CITY OF ALBUQUERQUE

February 7, 2017

**Re: Beehive Homes at Volcano Cliffs
Erosion and Sediment Control Plan
Engineer's Stamp Date 1-25-17 (E10E027)**

SWPP PLAN
SCALE: 1"=20'

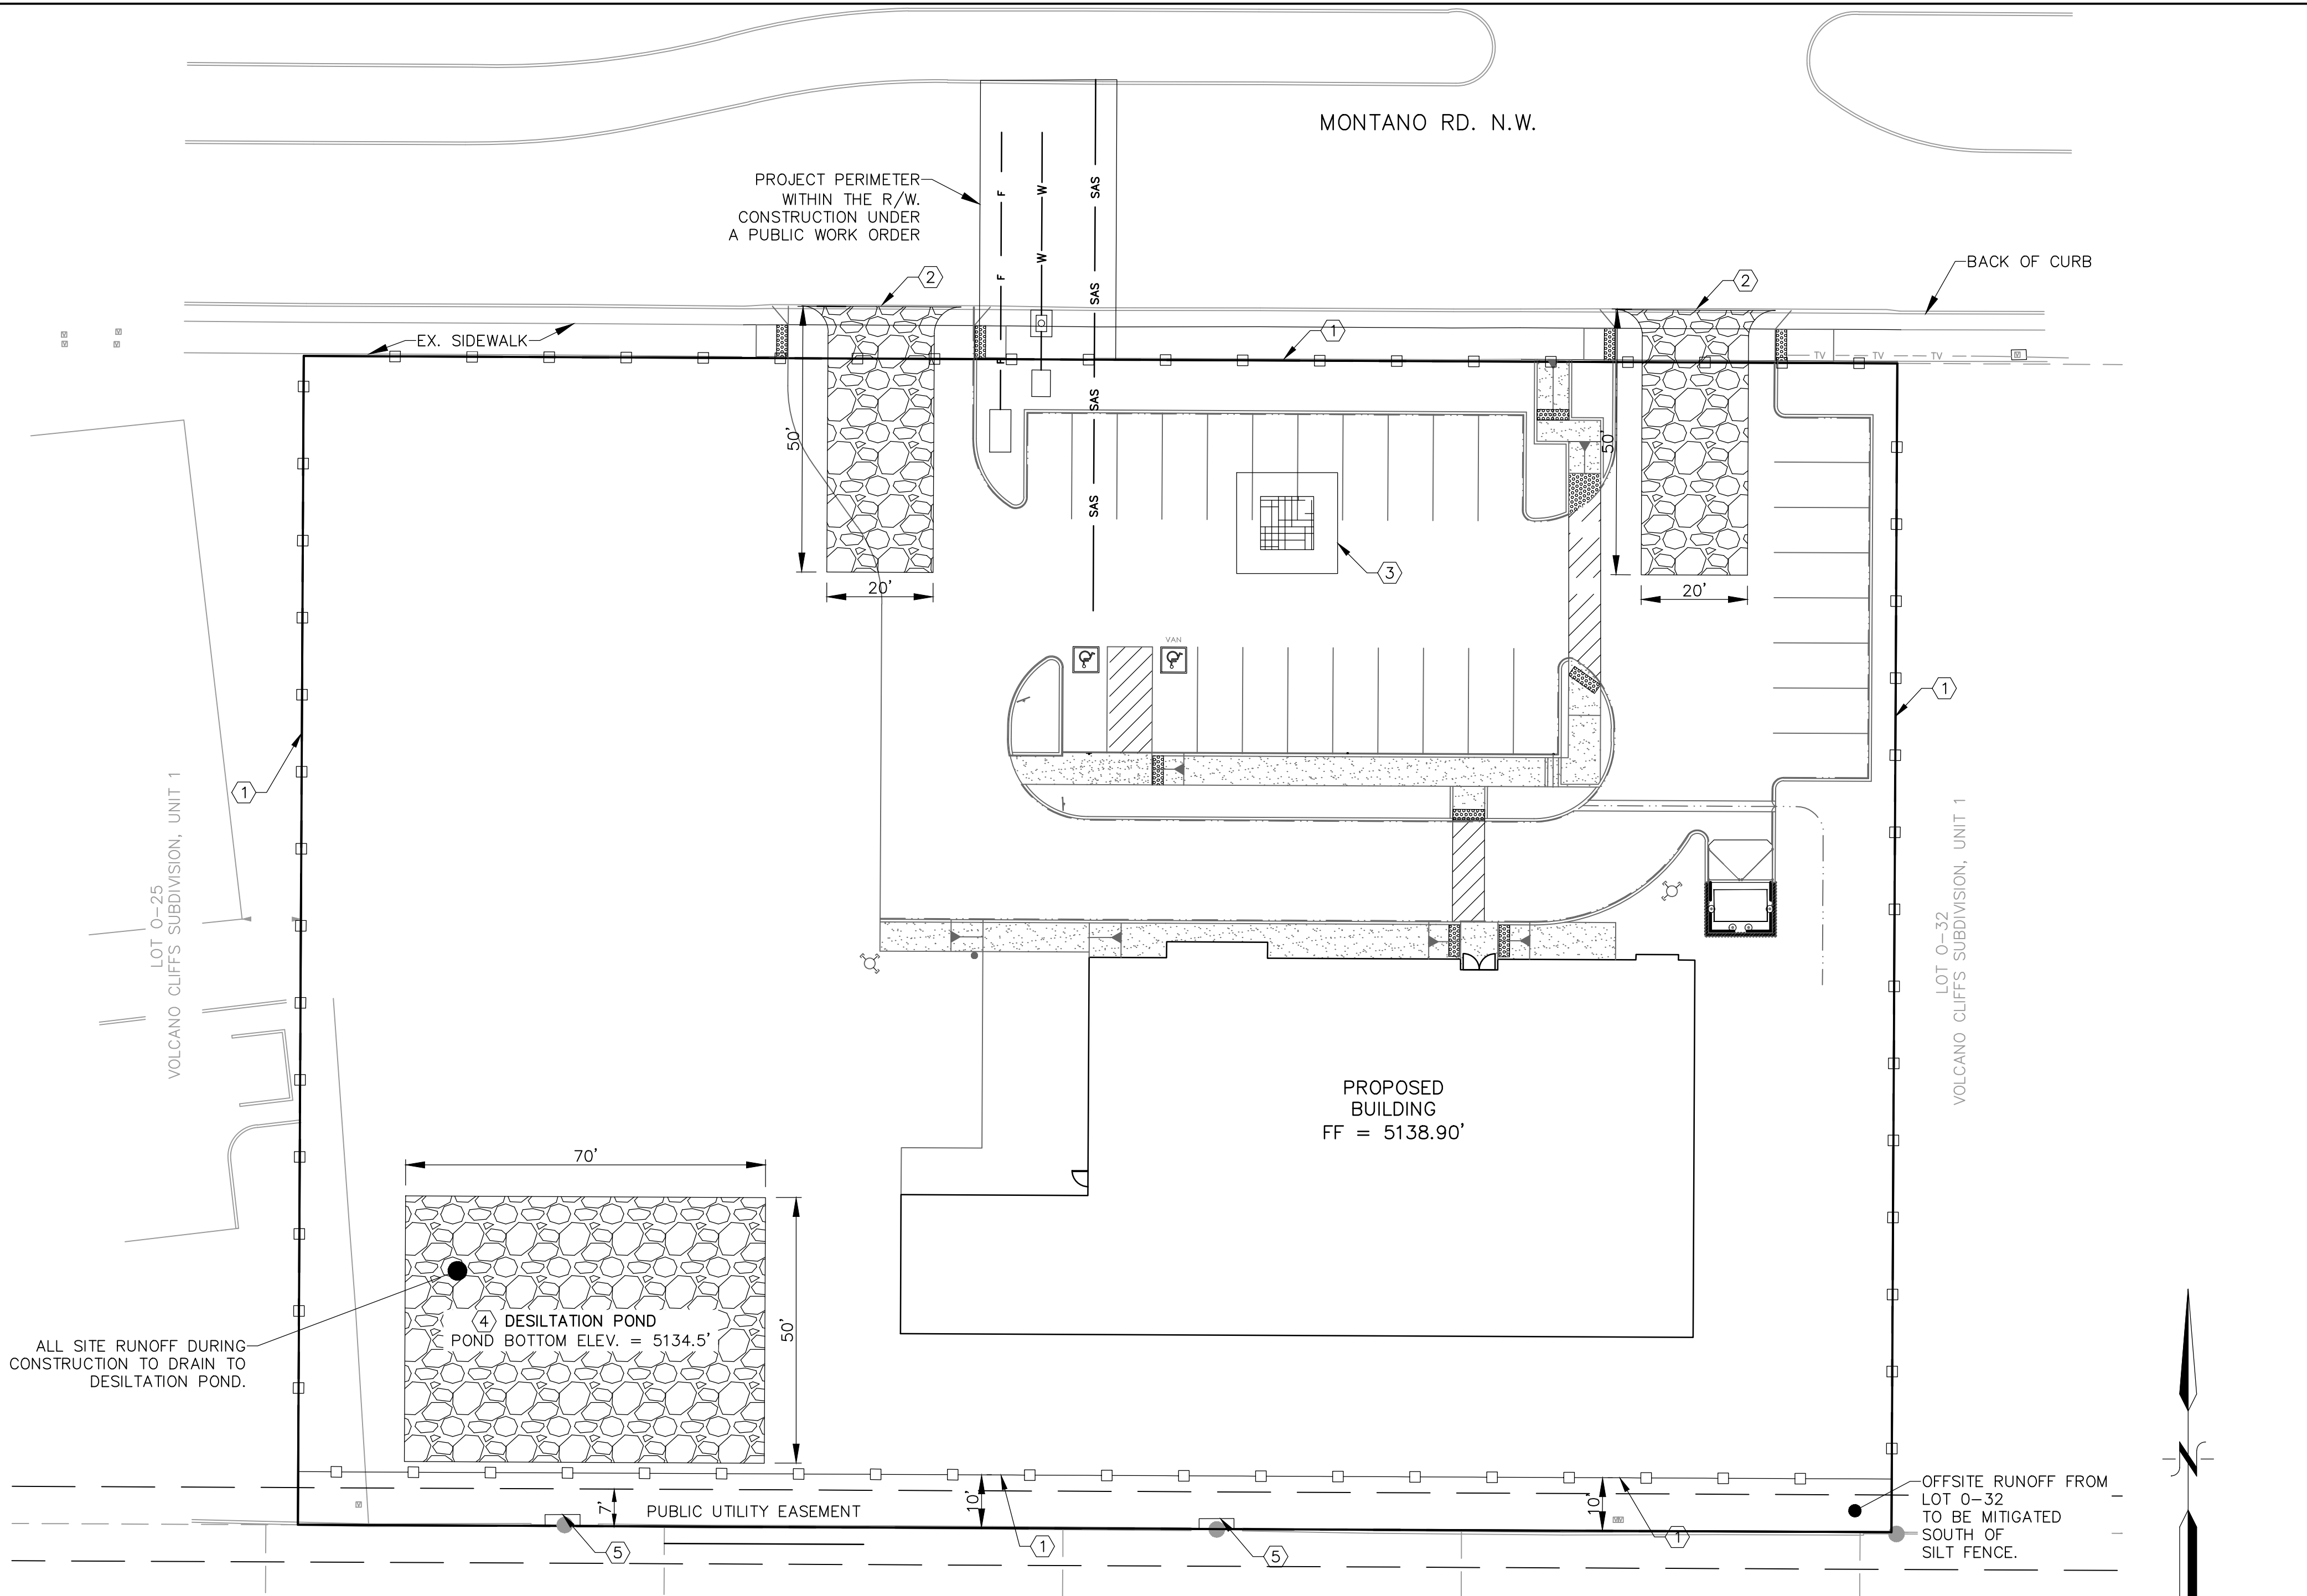
1. Provide proposed contours. Depending how the site will be graded may change BMPs (e.g. It is better to put the stabilized entrance on the high side of the site as they are not a good BMP if they receive drainage).
2. In the existing condition, the site drains from NW to SE. Why is the sedimentation pond in the SW corner rather than the SE corner?
3. Include BMPs for the construction activity in Montano Rd; add a keyed note for a wattle/filter sock on the downhill edge of the street cut and add a note to place the dirt on the uphill side of the cut.
